Application H01-0687-22
Location 6 STONE GATE COWBIT SPALDING PE12 6AH
Proposal Proposed detached garage & new frontage wall

Name Greg Watkinson
Address Conservation Officer

Date Submitted 15-09-22
For/Against Comments

SITE PLAN - PROPOSED
1/250.

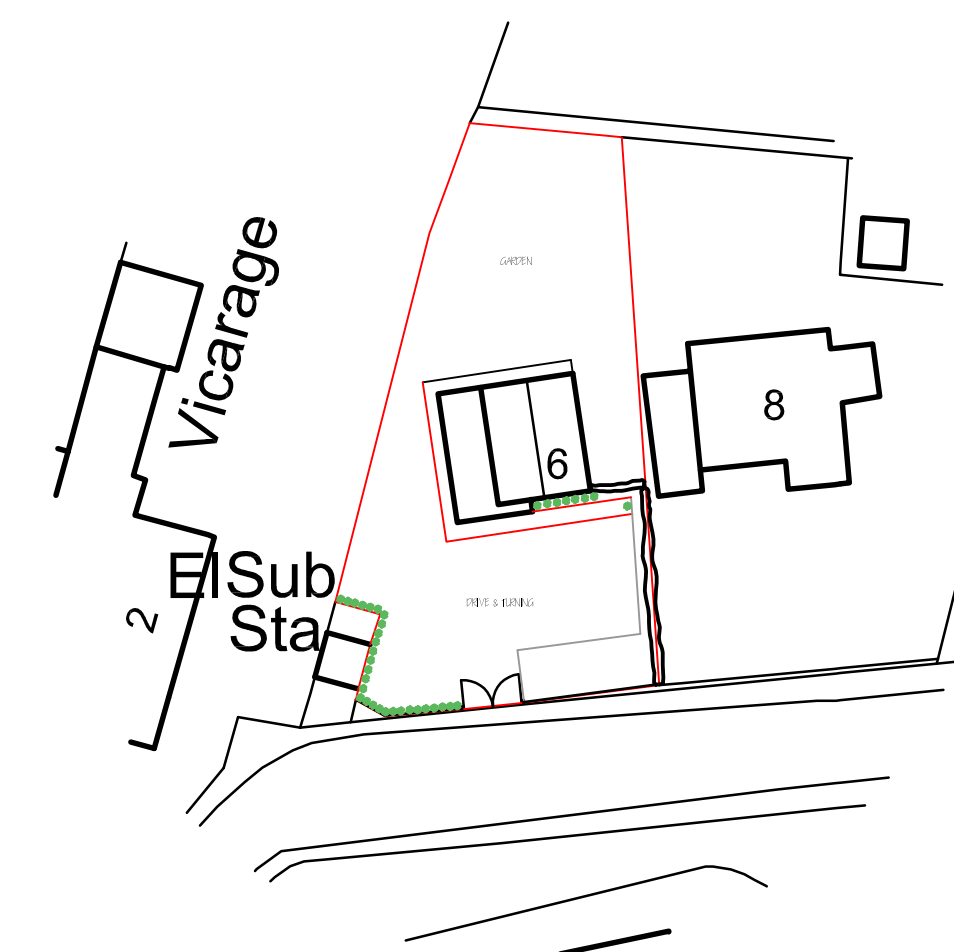
I wish to object to this proposal on conservation grounds. As a grade I listed property, the adjacent church of St Mary is amongst the very most important listed buildings in the entirety of South Holland. To erect a modern, featureless garage block on the far Southern boundary of the host property's curtilage - abutting the roadway and therefore in the closest possible proximity to the Grade I listed church would be to introduce into this specific setting a feature which is incongruous to the character of the site, and neither better reveals nor preserves the significance of the listed building, as is a requirement for all developments within the setting of a listed building, as outlined in Section A, Para. 3 of Policy 29 of the South East Lincolnshire Local Plan (2019).

Furthermore, the adjacent Vicarage can easily be considered to be a non-designated heritage asset and to place a large, roadside structure in the proposed location would undoubtedly impact upon characterful views and therefore the setting of the Vicarage in its context alongside the Grade I listed church, when approaching from the East, representing a further harmful design impact upon the local character and distinctiveness.

To the west of the host property is a large portion of side land which could easily accommodate such a proposed structure in a manner which, akin to the house is drastically set back from the road, therefore, minimising the visual impact upon both the grade I listed building and the associated vicarage. I would suggest that a proposal to place the proposed on that aforementioned side land would be viewed much more favourably from a conservation perspective. However, in this proposal's current format, I must suggest that the officer refuse permission on the above grounds in addition to any other considerations deemed relevant to this case.
